**Chris Berg, PE**  
**Structural Engineer**  
1126 Boxcar Way, Apex, NC 27502  
919-623-7300

Re: 4071 McLean Chapel Church Road, Bunnlevel, NC

At your request, I have reviewed the framing of the new garage at this address. In particular, I reviewed the attic framing over the garage area. The attic framing is composed of 2x10's @ 24" o.c.. These are supported by the exterior walls, as well as a central girder down the middle of the garage. The central girder is comprised of 3-2x10 with a overall span of 20'-8".

SECTION VIEW

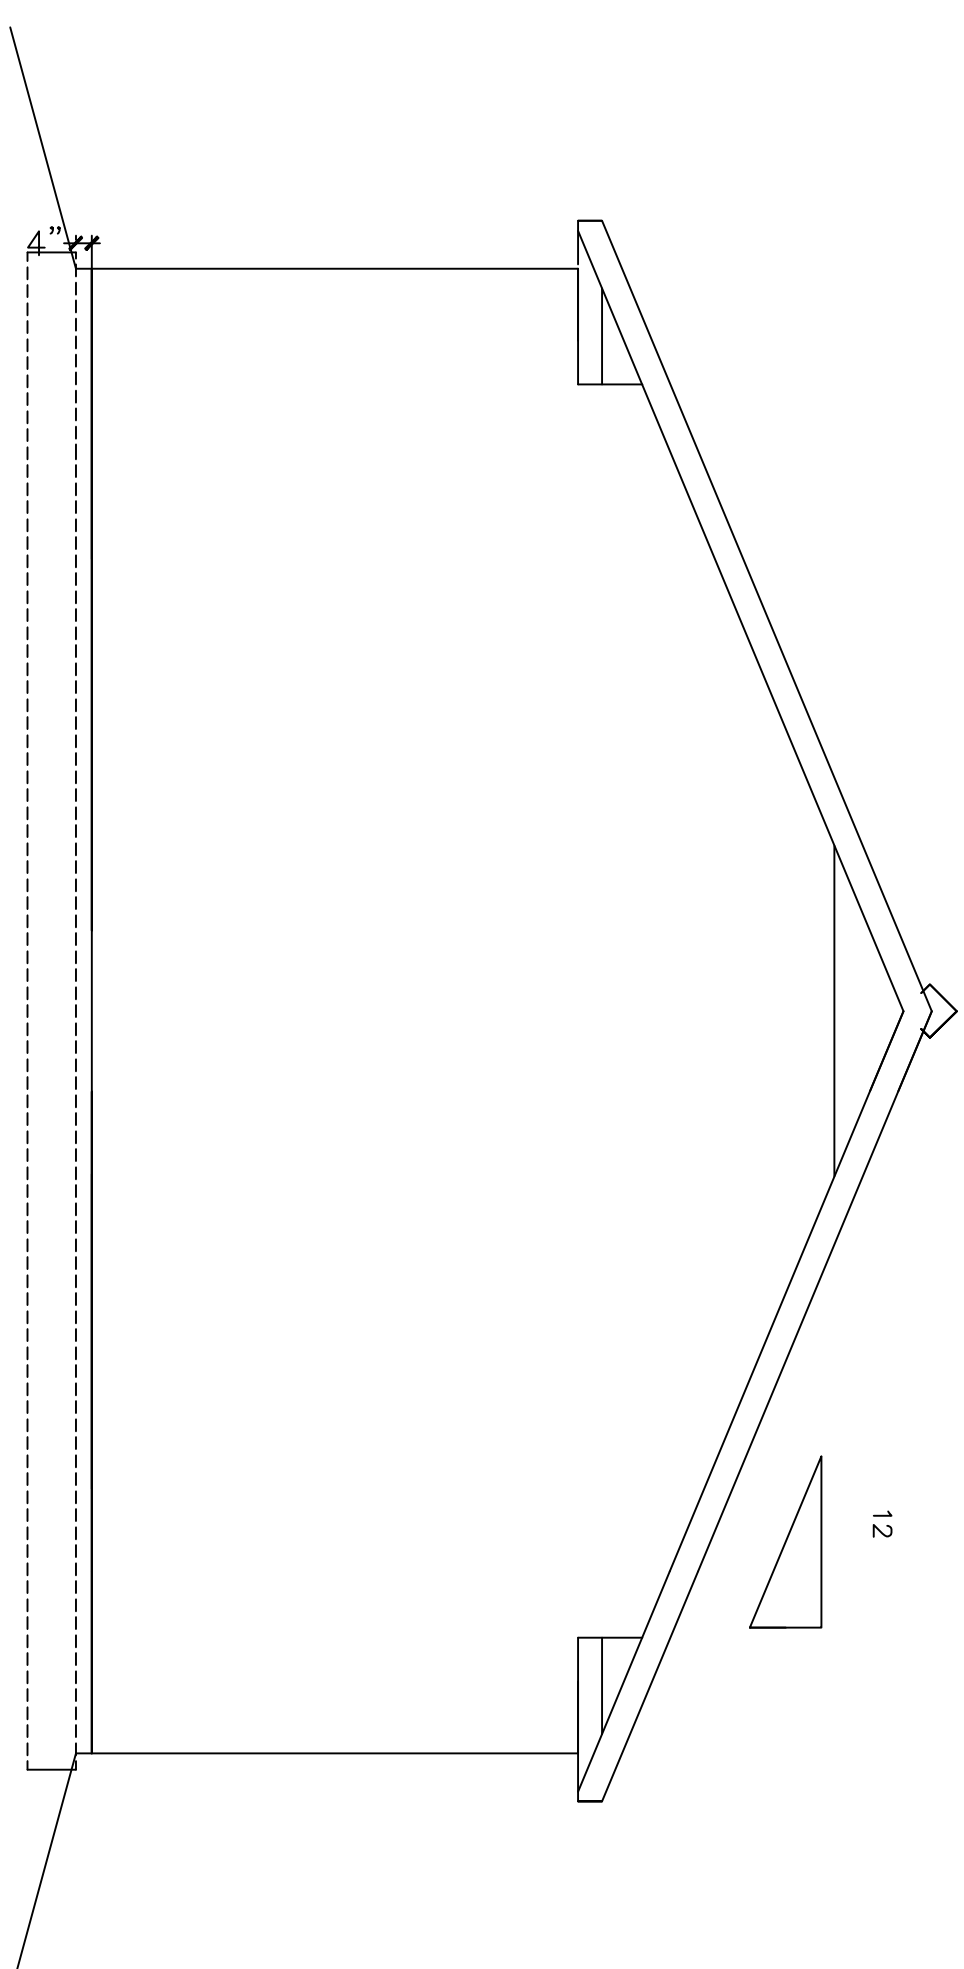
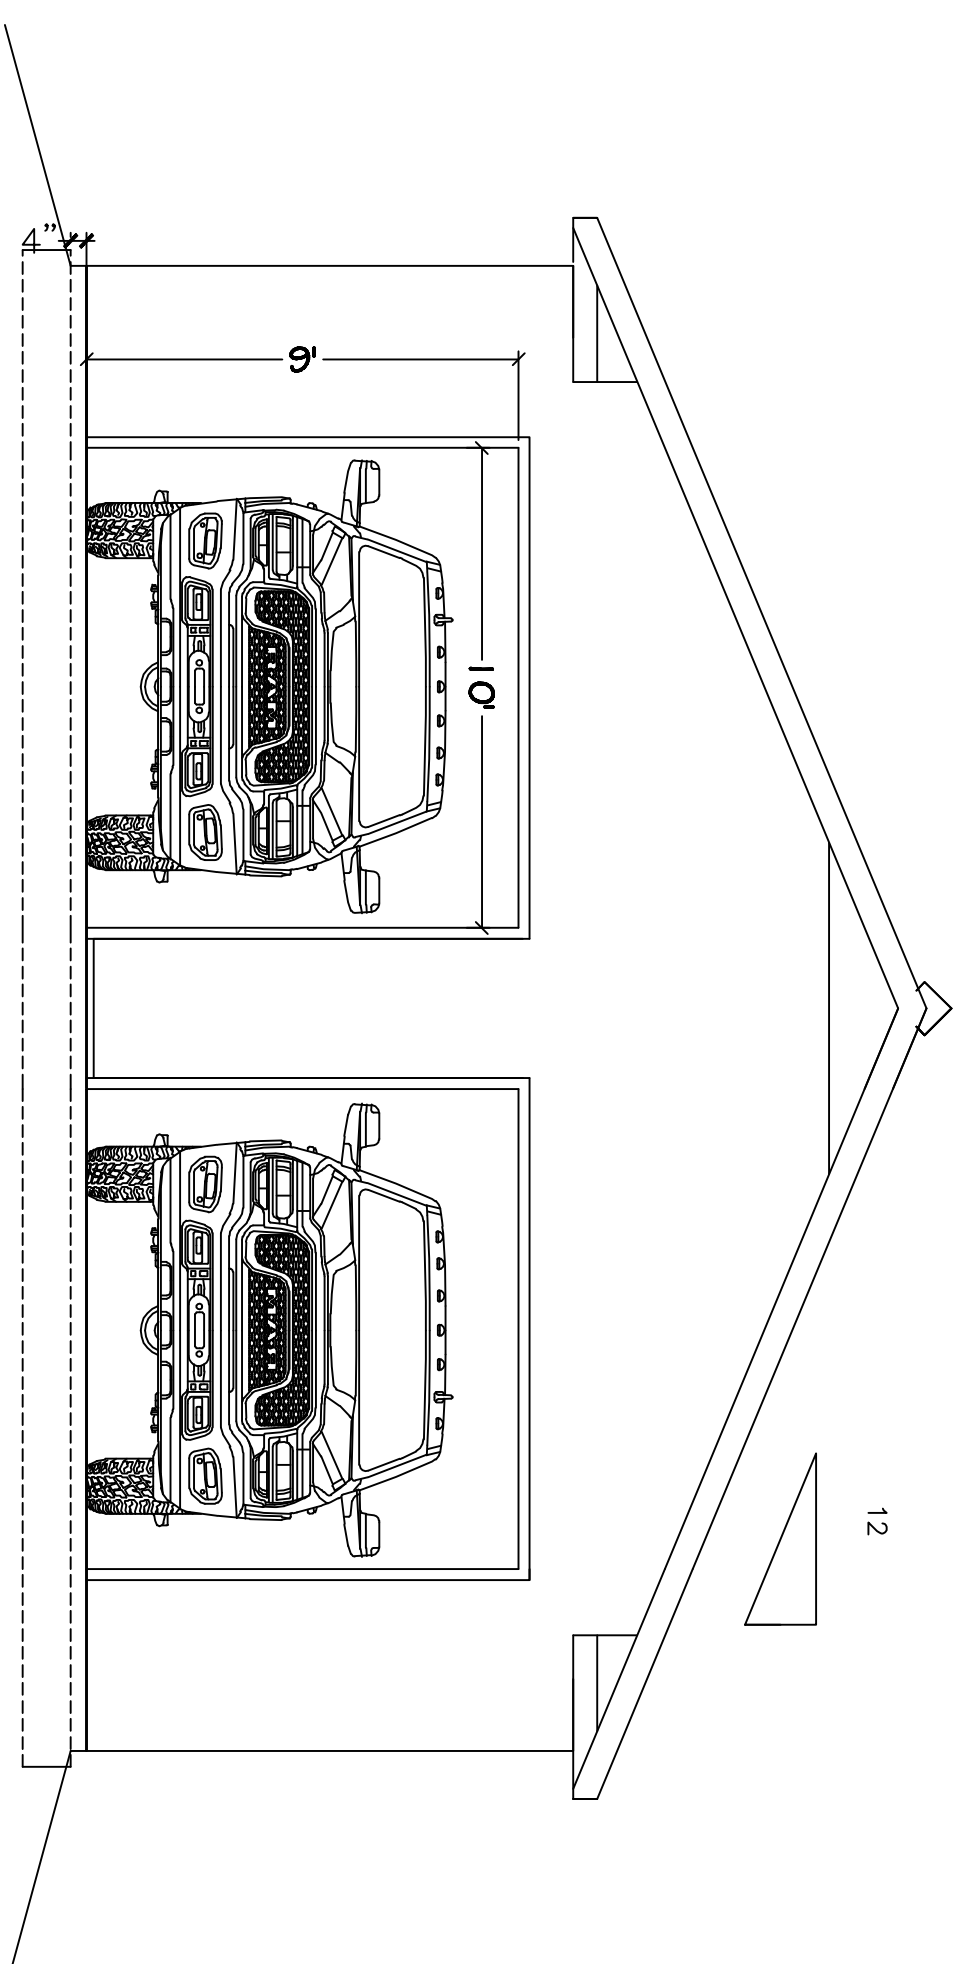
In order for this system to safely support the required attic loads, a post must be installed midspan of the 3-2x10 girder (cutting the span to 10'-4"). This post may consist of a 4x4 posts, 6x6 post, or a built up stud post. This new post may bear on top of the slab on grade with an appropriate post base anchorage.

Once this post is installed, it is my professional opinion that the attic framing of the garage will safely support all loads required by the NC State Building Code – Residential (2018)
